Examination Deadline 6 3rd April 2020

ELM CORNER RESIDENTS GROUP response to changes 8 & 9 to the DCO

Old Lane/Elm Lane junction

Figure 4.1 – Proposed amendments to the visibility splay on Old Lane/Elm Lane corner (extract of dwg: HE551522-ATK-HGN-XX-SK-CH-000093_C01)

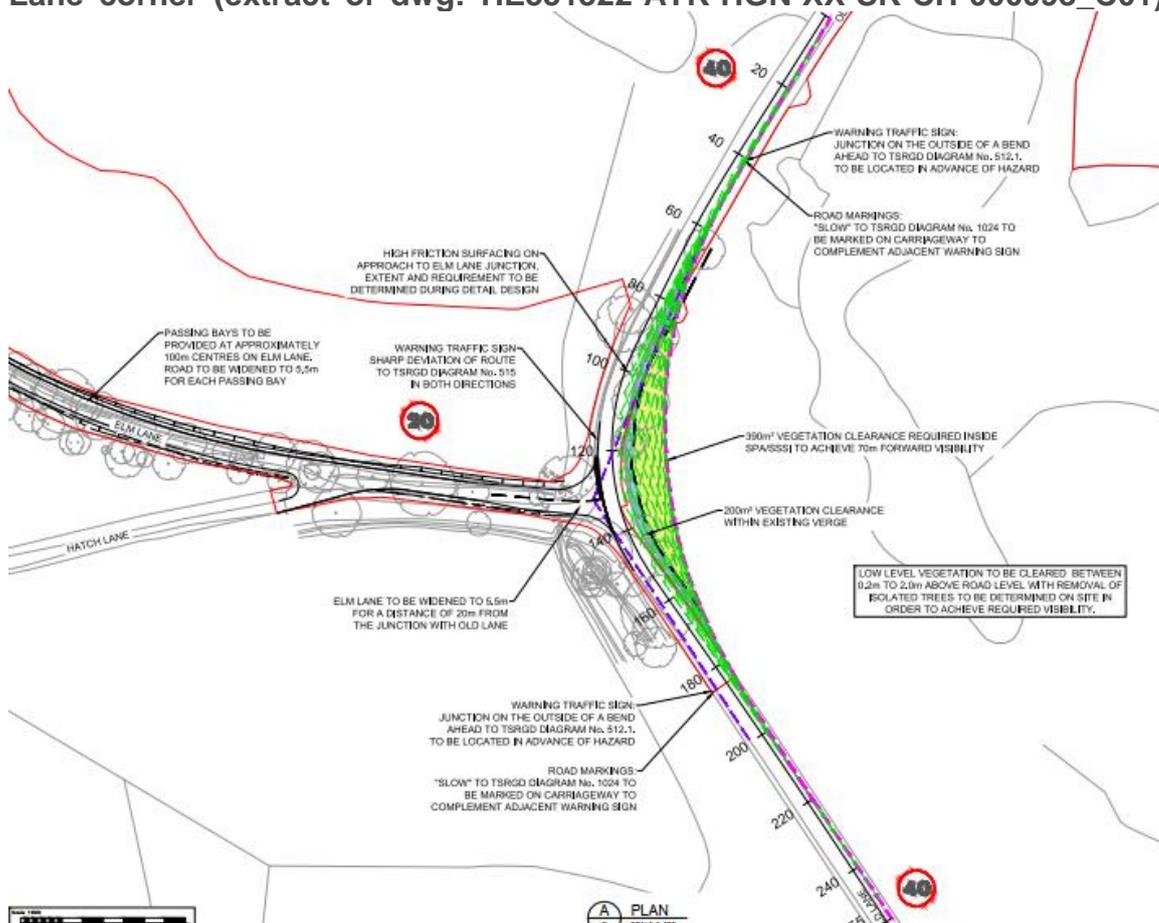
2. However, we do not believe that the slowing measures indicated in [HE551522-ATK-HGN-XX-SK-CH-000093_C01.pdf](#) are sufficiently robust to slow vehicles down. As previously stated, we believe that SCC would be able to provide statistics showing that vehicles regularly exceed the 40 mph speed limit on Old Lane and that there have been many accidents right on this bend. We anticipate that with a freeflow access from M25, vehicles will enter Old Lane at speed from the motorway and will not follow the 40 mph restriction.

3. Old Lane is a renowned rat run for vehicles avoiding traffic problems on the M25 from junction 10 to junction 11 and the 40 mph restriction on this road is rarely adhered to.

4. The better sight line proposed by removal of vegetation could encourage greater speeding along this stretch of road.
5. We do understand that there is no extant planning permission for the former Wisley airfield but do believe that the probable extra traffic movements if the 'newtown' is built have been included in the modelling for the A3/M25 junction improvements. Is it therefore not sensible to consider, also, the large increase in traffic along Old Lane which will be occasioned by this development.

The construction of a mini roundabout at the Old Lane/Elm Lane junction. This, as we have mentioned before in our representations, is our preferred option and by far the best option for road safety for the residents of Elm Corner and the wider public.

In addition we feel that the installation of rumble strips to alert drivers to the upcoming bend and/or speed activated warning signs. These measures would be 100% more effective than a mere SLOW sign painted on the road.

Figure 5.1 – Proposed revised layout of Wisley Airfield construction compound following Change 9 (extract of dwg: HE551522-ATK-LDC-A3_L1-DR-ZL-096502)

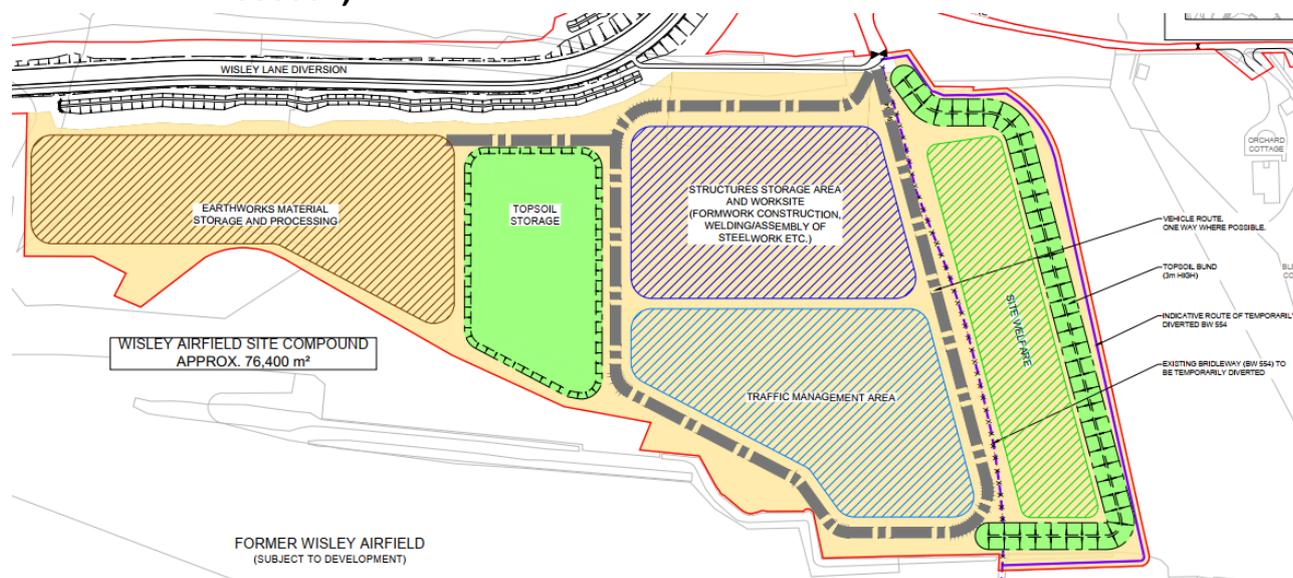
2. We believe the review of the worksite proposed has resulted in it becoming significantly larger than the original proposed construction compound. Please advise.

3. We do not agree that the environmental effects of the site as now proposed would not have any material change to the effects already assessed. We refute this and request that we are provided with the evidence to support this statement. The additional uses on the site include materials processing, structures storage area and worksite (formwork construction, welding/assembly of steelwork), ancillary traffic management area and welfare facilities. These will unquestionably present material changes to the noise, dust and light pollution and increased traffic movements.

6. We can see that drawing [HE551522-ATK-LDC-A3 L1-DR-ZL-096502-Rev 0.pdf](#) shows the earthworks material storage and processing is to be located at the furthest point from EC within the compound but that the equally pollutant structures storage area to include a worksite for construction, welding and assembly of steelwork will be positioned close to EC. This is completely unacceptable.

10. The siting of this works compound will ensure that the prevailing south westerly winds will cause serious dust, dirt and noxious odour nuisance to the residents over a 2 -3 year period.

As we have stated before the whole of this worksite could easily be located at the far southern end of the hardstanding at least a further 500 metres from the residential receptors located in EC.

We request that materials processing should not be carried out at this worksite and that materials should be transported to an already established and designated work yard which is not at such close proximity to a residential area.
